15 April 2011

**RE: EXHIBITION OF PROJECT APPLICATION FOR BROADWAY BUILDING –
UNIVERSITY OF TECHNOLOGY SYDNEY BROADWAY (MP 09_0212)**

I understand the project involves the construction of a new 12 storey building with basement parking for 160 vehicles, an architectural feature, and modifications to the existing Building 10 carpark to accommodate bicycle facilities and vehicle access for the Broadway Building, and bridge access between the two buildings.

BROADWAY ELEVATION - SCREEN
7352_CBL1_AK00495_C
21 FEBRUARY 2011

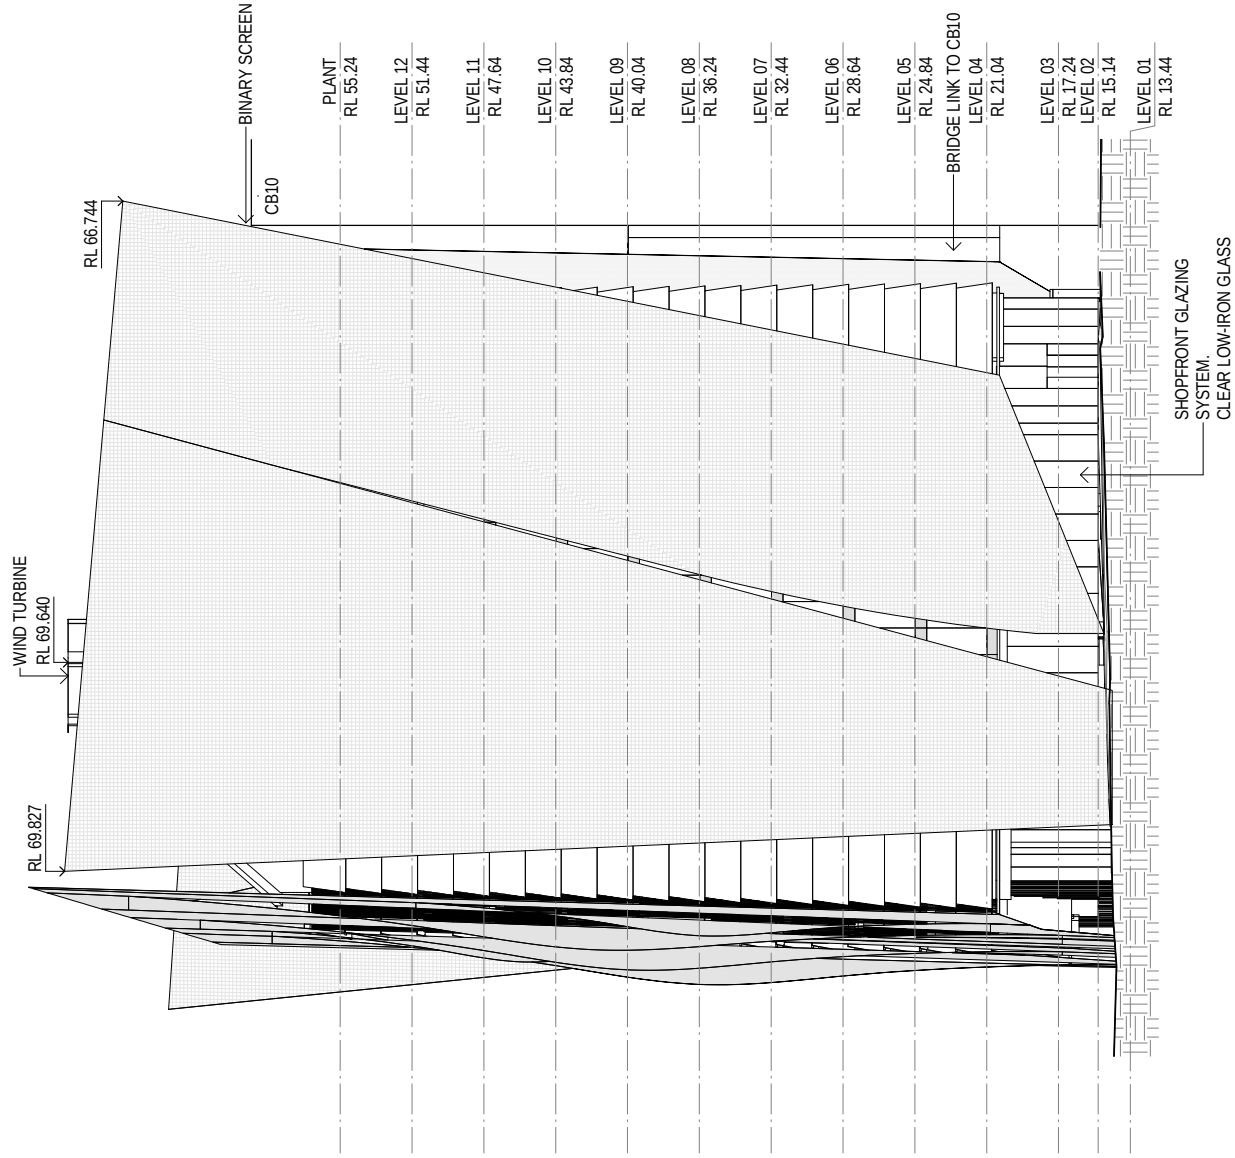
Concern is raised with the effect of the binary screen extending down to the footway level which places a physical barrier between the building and the street where people can walk on both sides of the screen. This screen will potentially provide a concealment hazard, especially when the building side is not illuminated. Measures shall be implemented to provide passive surveillance at night time, such as the provision of lighting within these corridors.

It is recommended that the external screen be adjusted to provide some weather protection along Broadway for improved pedestrian amenity. The distance that the screen is positioned off the face of the building at level 1 should be increased, and could be achieved by deflecting the screen and overhanging the footpath to provide a partial awning. The maximum degree of cover might be in the order of half of the footpath width. The length of the awning should be maximised along the Broadway facade and should be aligned with the height of the screen from the footpath level. In addition, the screen could be terminated in part or in full to a height of no less than 2200mm above the footpath to allow direct visual access to the activities within the building where appropriate. Any awning treatment will need to be higher than the minimum 2200mm and comply with Council's requirements. Alternatively, an independent lightweight weather protection awning should be required of the applicant to the satisfaction of the City of Sydney Council.

LANEWAY ELEVATION - SCREEN
7352_CBL1_AK00498_C
21 FEBRUARY 2011

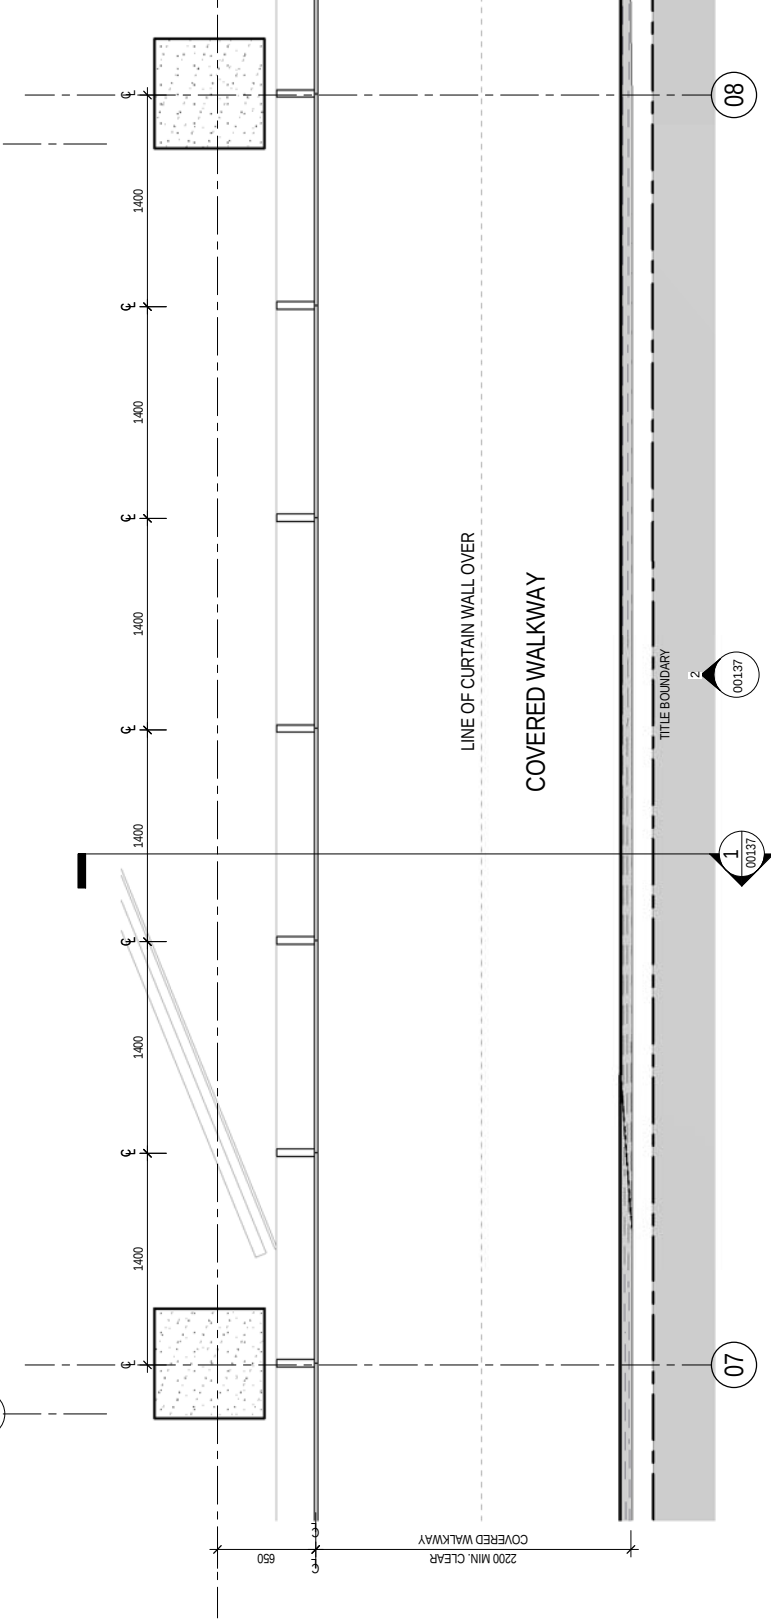
The Landscape Concept Plan provides insufficient detail of the proposed landscaping to the laneway. Whilst there is detailed information on growing mediums, the overall strategy and vision for the landscape architecture is not sufficiently demonstrated in the Concept Plan. For instance, the Landscape Design Report proposes opportunities for hanging elements and vertical growing structures, as well as several 'microclimate zones' within the laneway. These concepts are interesting and positive, however, the Concept Plan only shows a single row of 'tall open habit flowering trees' and no response to the various microclimate zones or vertical elements proposed.

The laneway provides a great opportunity for 'public' space away from the traffic of Broadway and activation by various uses. The proposed plan, however, showing the single row of trees does not illustrate how the laneway is intended to function or how the landscape responds to the adjacent built form or uses.

Accordingly, it is recommended that the Landscape Concept Plan be amended to include details demonstrating how the laneway could be designed to maximise opportunities discussed in the text of the Landscape Design Report. Montages of the laneway, and illustrative plans/elevations would assist to demonstrate the features of an improved design.

Existing street trees plan

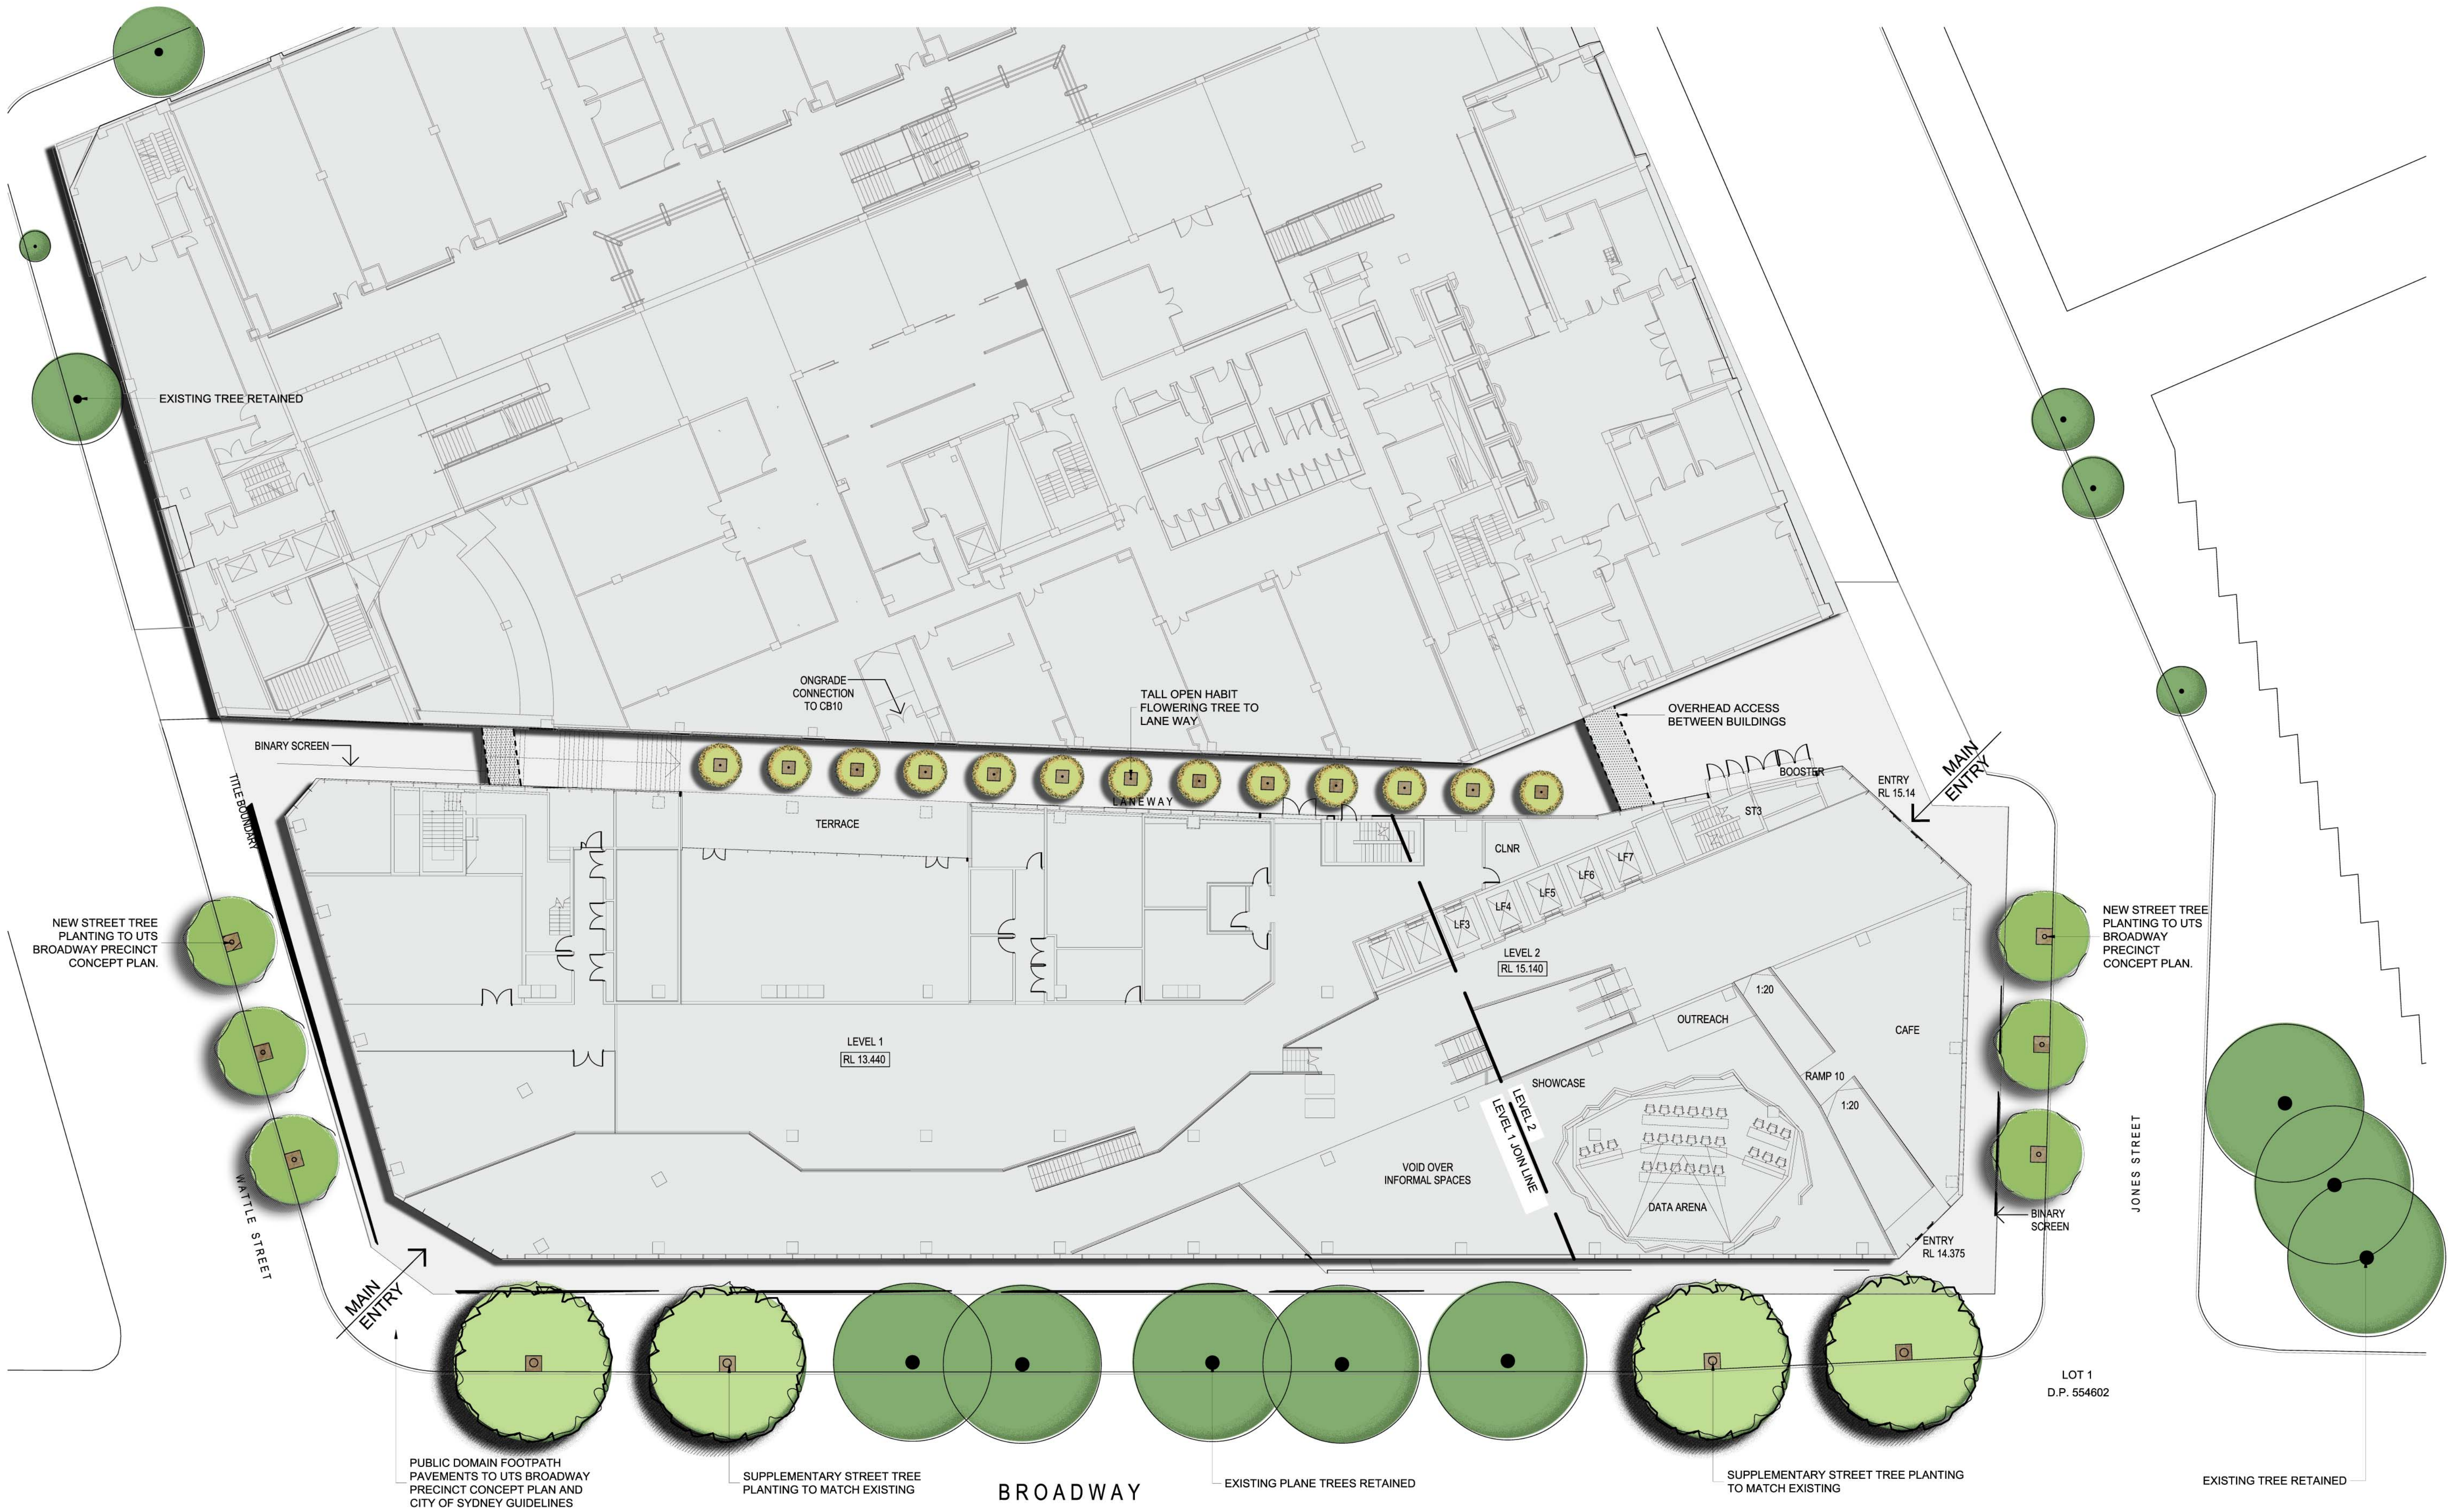
The current proposal retains the five Council street trees located along Broadway which must be protected during all stages of development. The proposal to plant new street trees shall be in accordance with the City's *Street Tree Master Plan*. The street tree plan shall be submitted to Council's Tree Management Unit for approval to ensure the tree species and technical specifications for tree selection, planting and maintenance are in accordance with the approved *Street Tree Master Plan*.
